Design Compliance Statement

Project: 24-1045 UNSW G25

Landscape Architects: Arcadia Landscape Architecture Pty Ltd

LANDSCAPE SITE PLAN

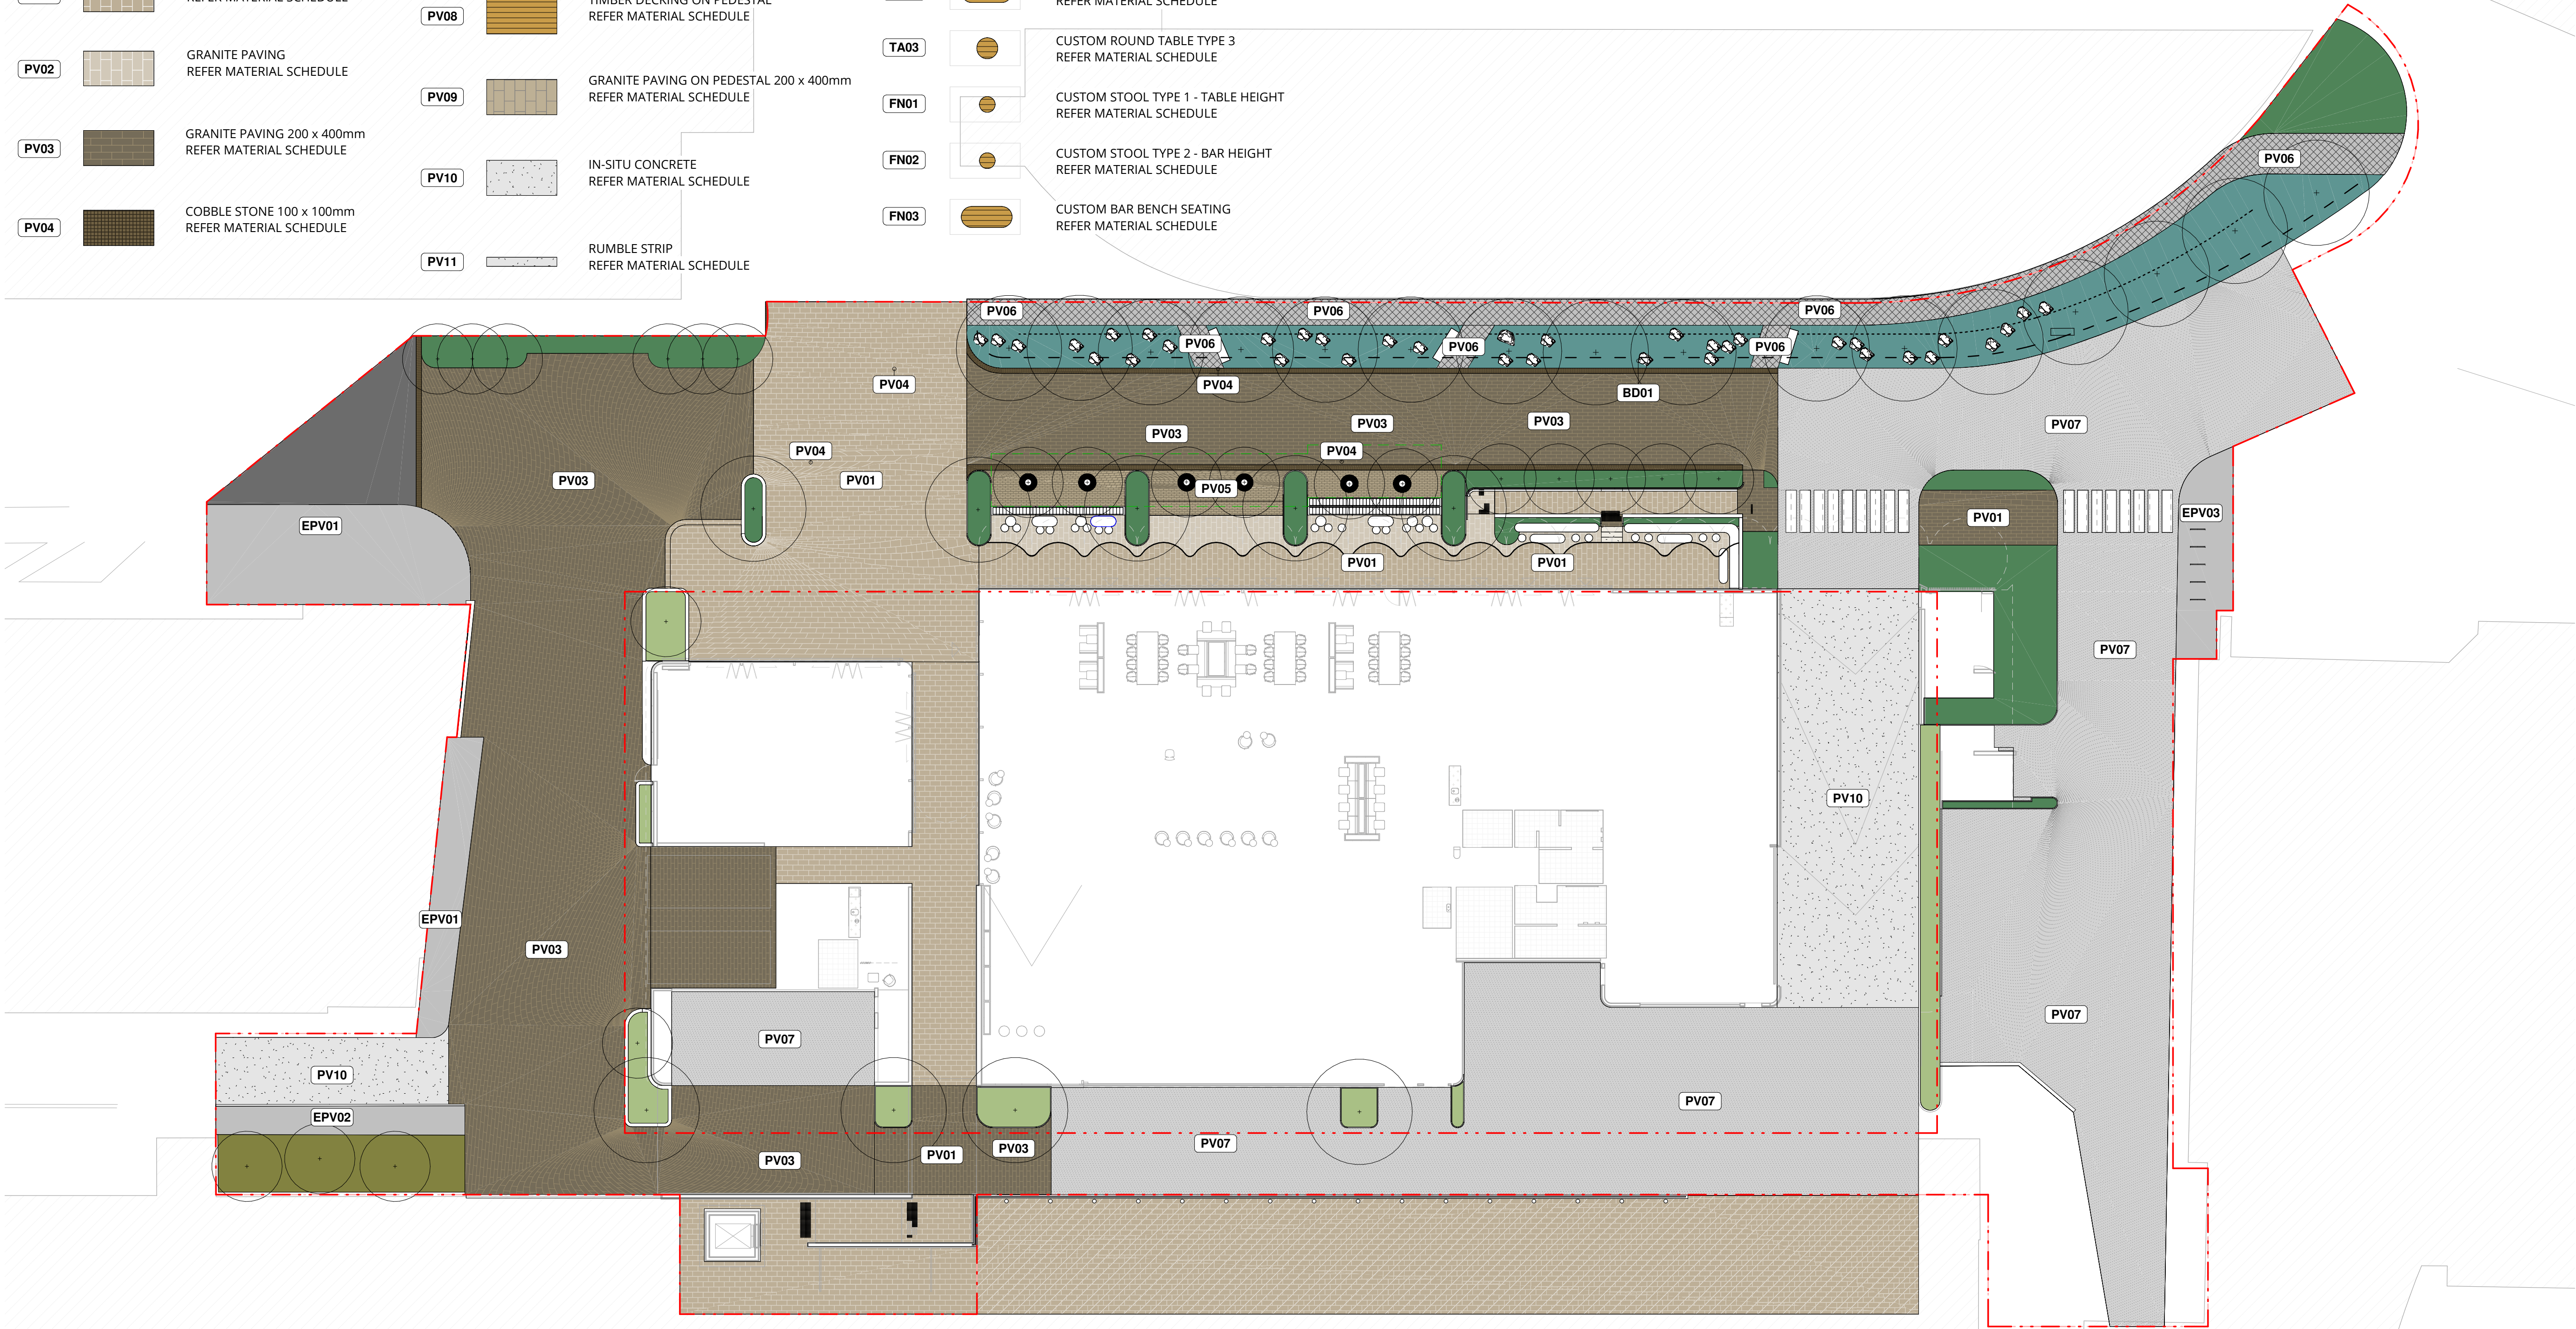
Our Ref	DPHI Response	Actions Required	Consultant Responsible
1.0	The Landscape Plans submitted with the RtS provide detailed specifications of some aspects, but no overall updated Landscape Site Plan is provided. Provide an updated Landscape Site Plan.	Landscape Architect to issue revised landscape site plan	Landscape Architect
2.0	Confirm the updated planting remains consistent with the Water Sensitive Urban Design and canopy objectives addressed in the original Landscape Report.	Landscape architect to advise.	Landscape Architect

Item 1.0: See attached Site Plan
